SANDSTONE CARESANDSTONE CARE
SITE DEVELOPMENT PLAN
LETTER OF INTENT

REQUEST

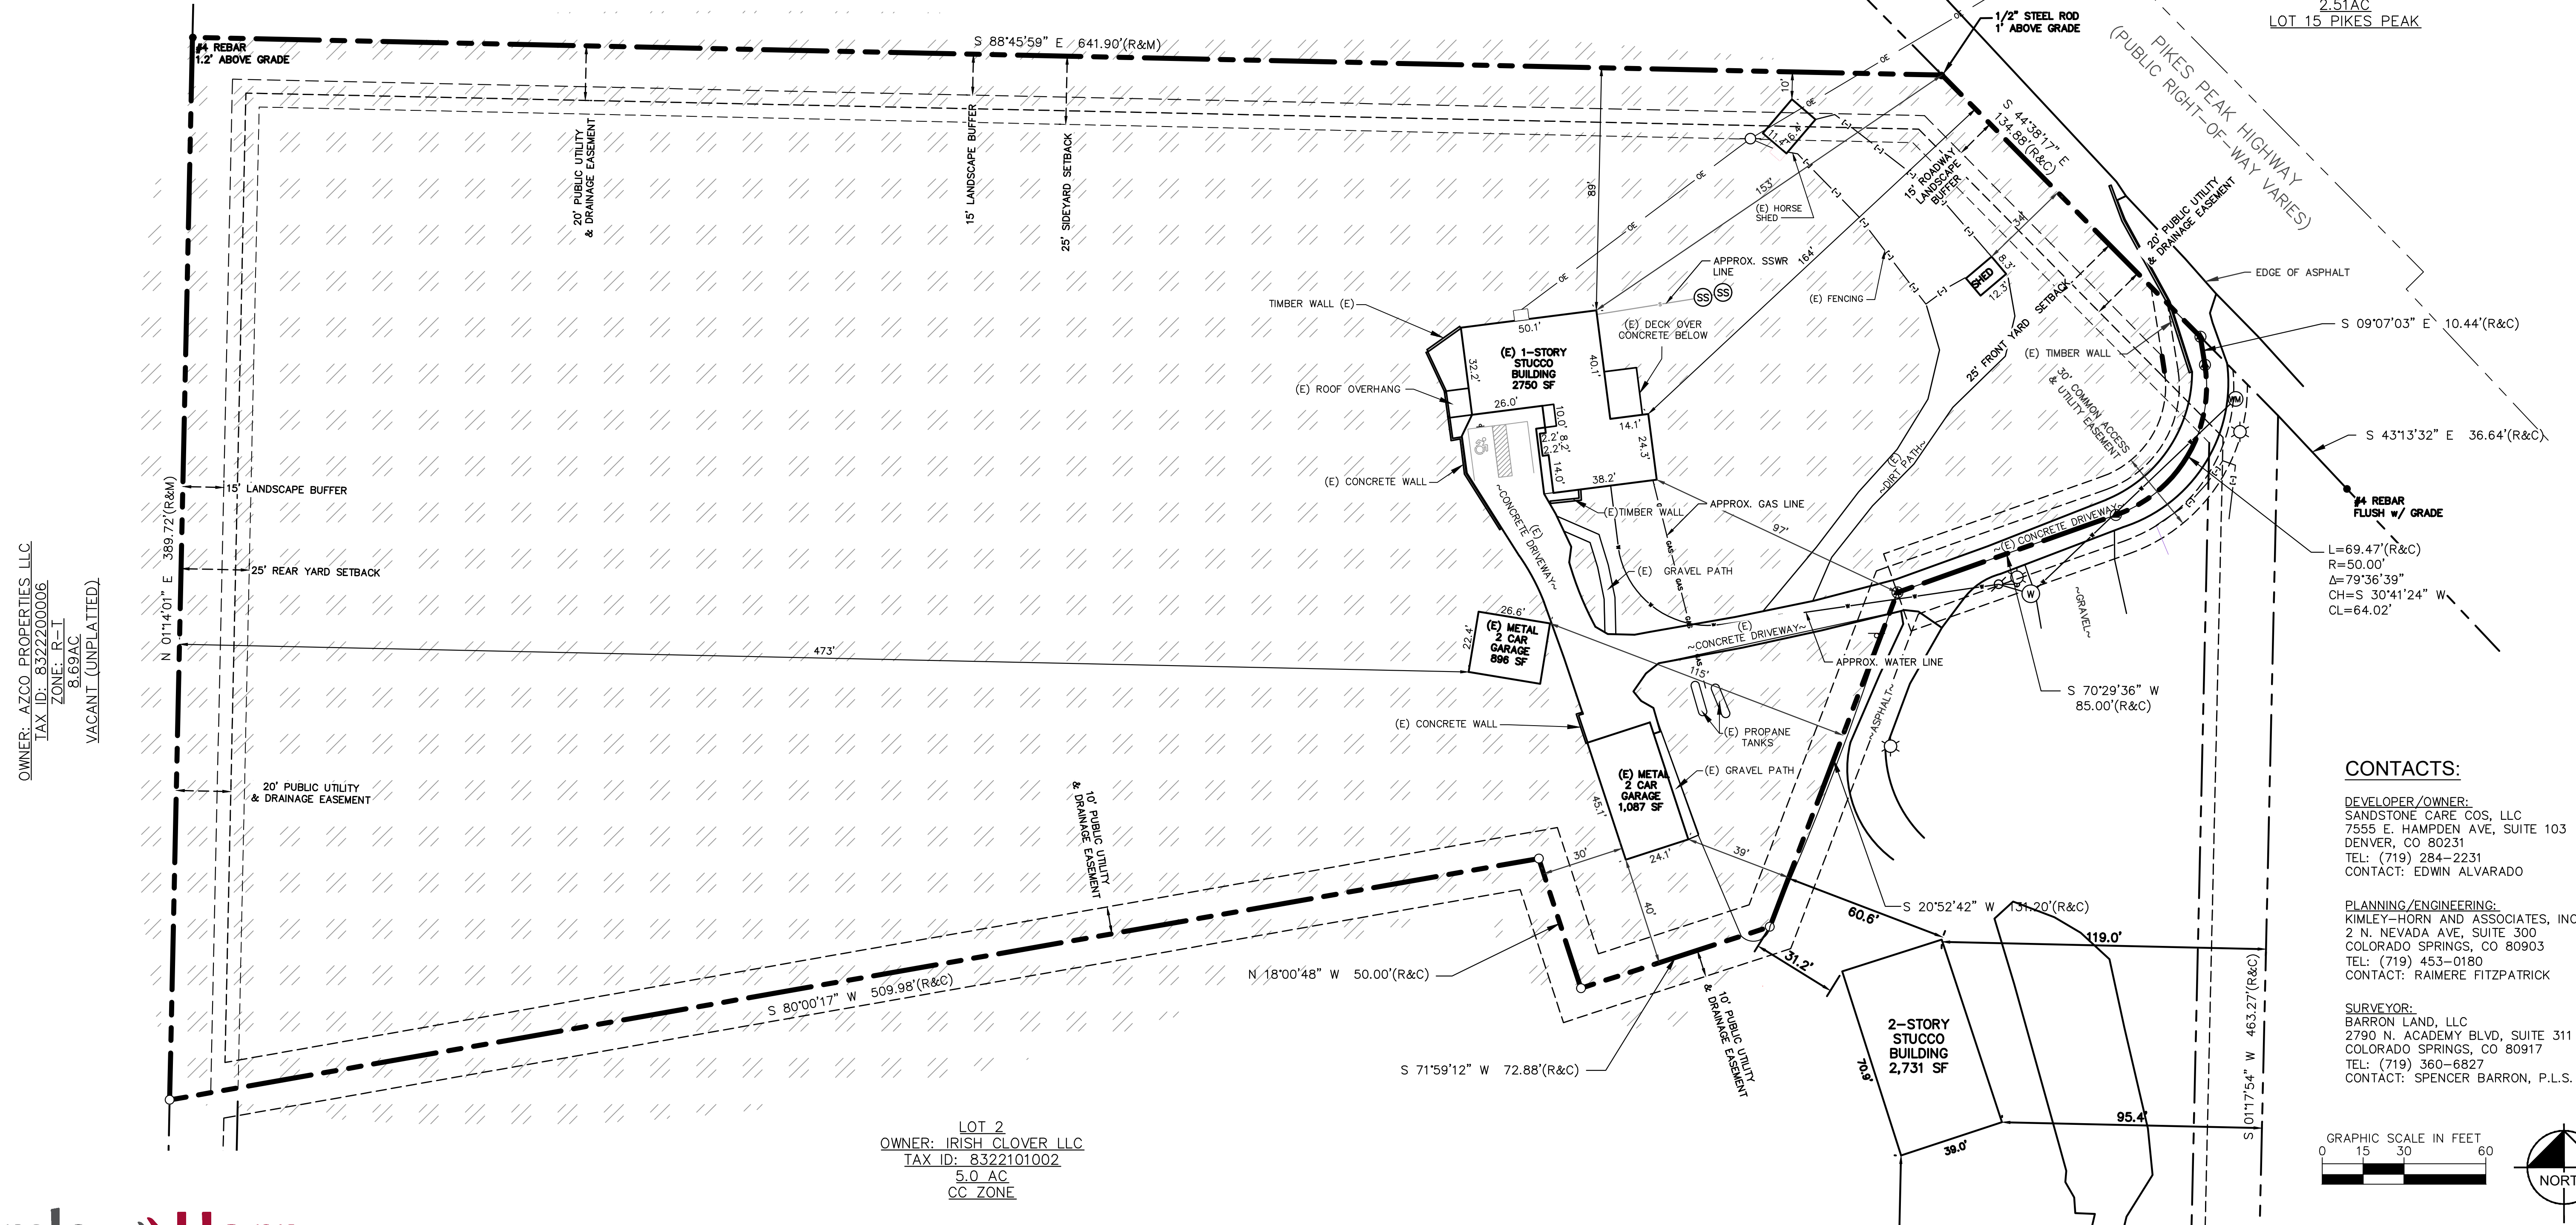
The development plan identifies a 15' roadway landscape buffer against the Pikes Peak Highway frontage and 15' non-residential/residential use buffer against the RT zoned properties to the north and west of the site. Per the Code, 5 trees are required within 1 tree/30 linear feet of roadway frontage ($134.88' \text{ frontage} / 30 = 4.46 \text{ trees}$). 1 tree/25 linear feet is required within “use” buffer area. A total of 16 trees are required along the northern 691.9' boundary and 16 trees are required along the western 389.72' boundary. the existing mature trees on site more than exceed the required number of buffer trees required. the applicant requests that the existing tree cover be counted to satisfy the various categories of landscaping buffer requirements.

This will require a justification of alternative landscaping per LDC Sec. 6.2.2(A)(4). Please provide specific justification for an alternative landscape request per this section of the Code.
